SAVE OUR SANDLINGS

Offshore Wind Farms
EAST ANGLIA ONE NORTH PINS Ref: EN010077
&
EAST ANGLIA TWO PINS Ref: EN010078

response from
Save Our Sandlings

Responses to Issue Specific Hearing 6 held 29th January 2021 via Microsoft Teams

| | Sheet Number: Sheet 1 of 12 | | | | | | | | | | | |

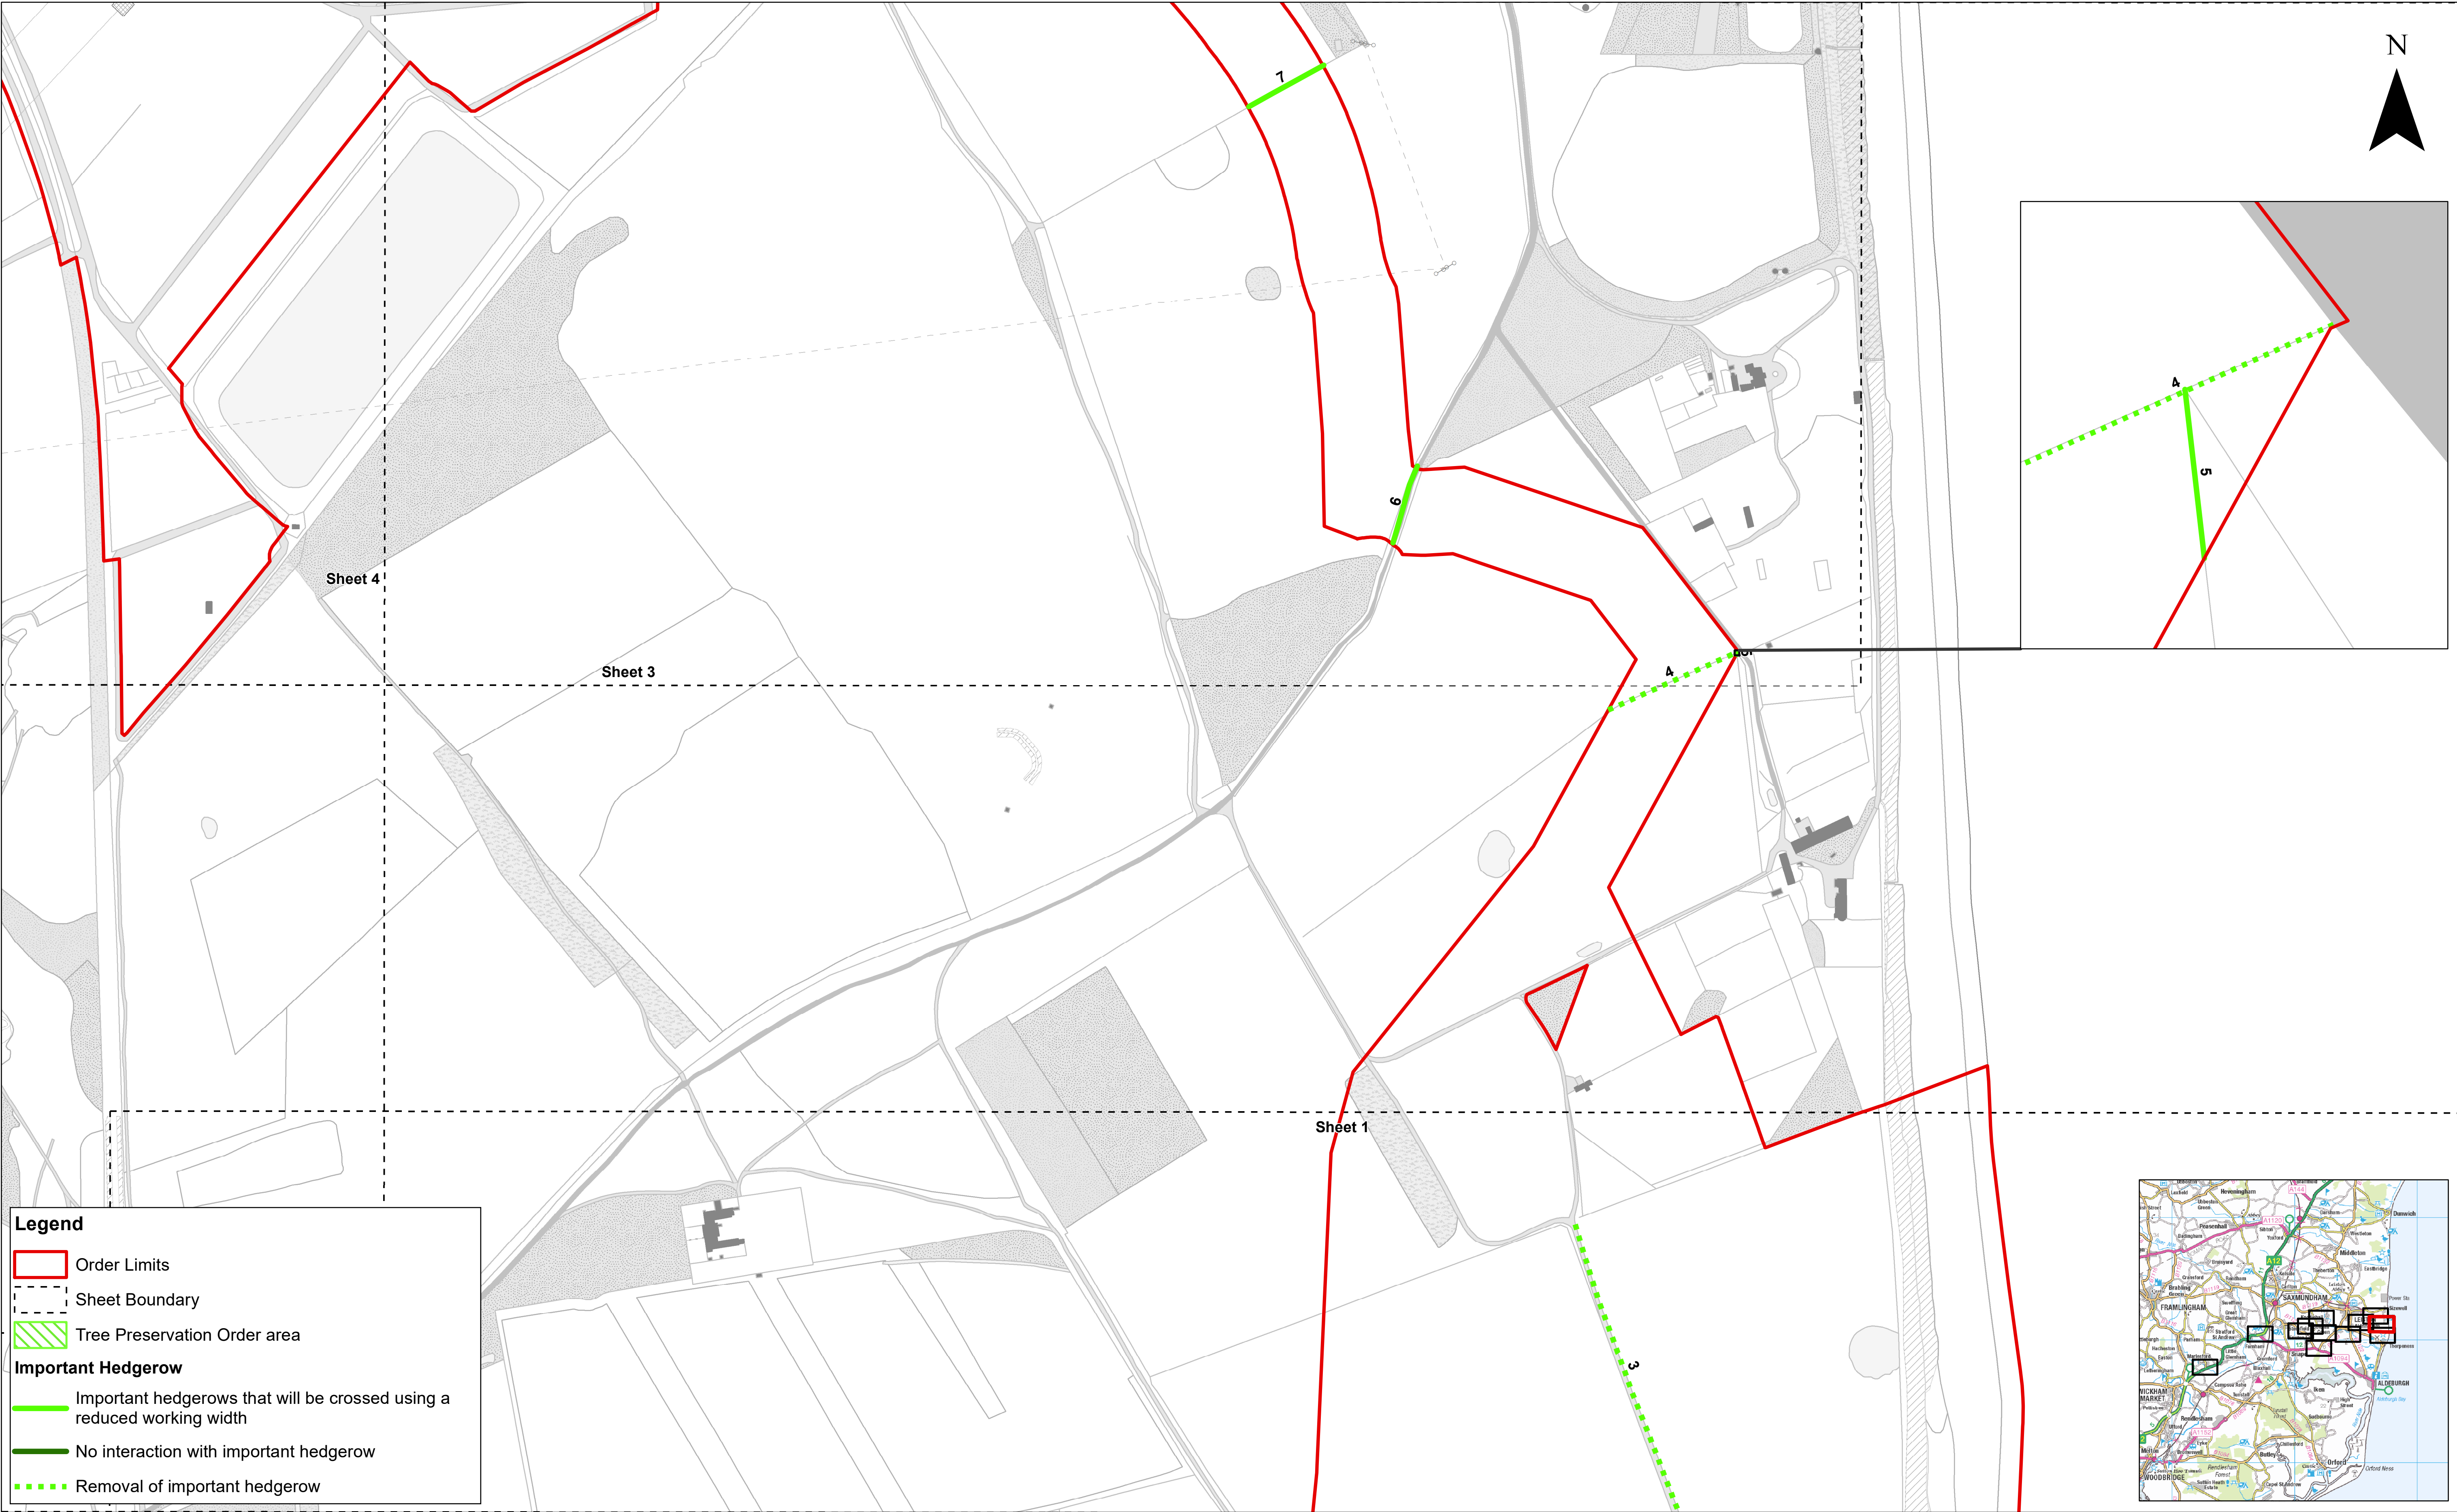
We ask that Hedgerow 1 on sheet 1 of 12 of the important hedgerow and tree preservation order plan⁵ is removed from Schedule 11 Part 1 'Removal of important hedgerows'. This is an ancient right of way known as a Holloway⁶; centuries old trackways worn down by the passage of time. An alternative route has been suggested avoiding the need to remove or damage this rich and diverse habitat. An unaccompanied site inspection 27th January 2021 by the examining panel has been completed in this regard. It is important to preserve this unique feature in its entirety for the benefit of wildlife and visitors to the area.
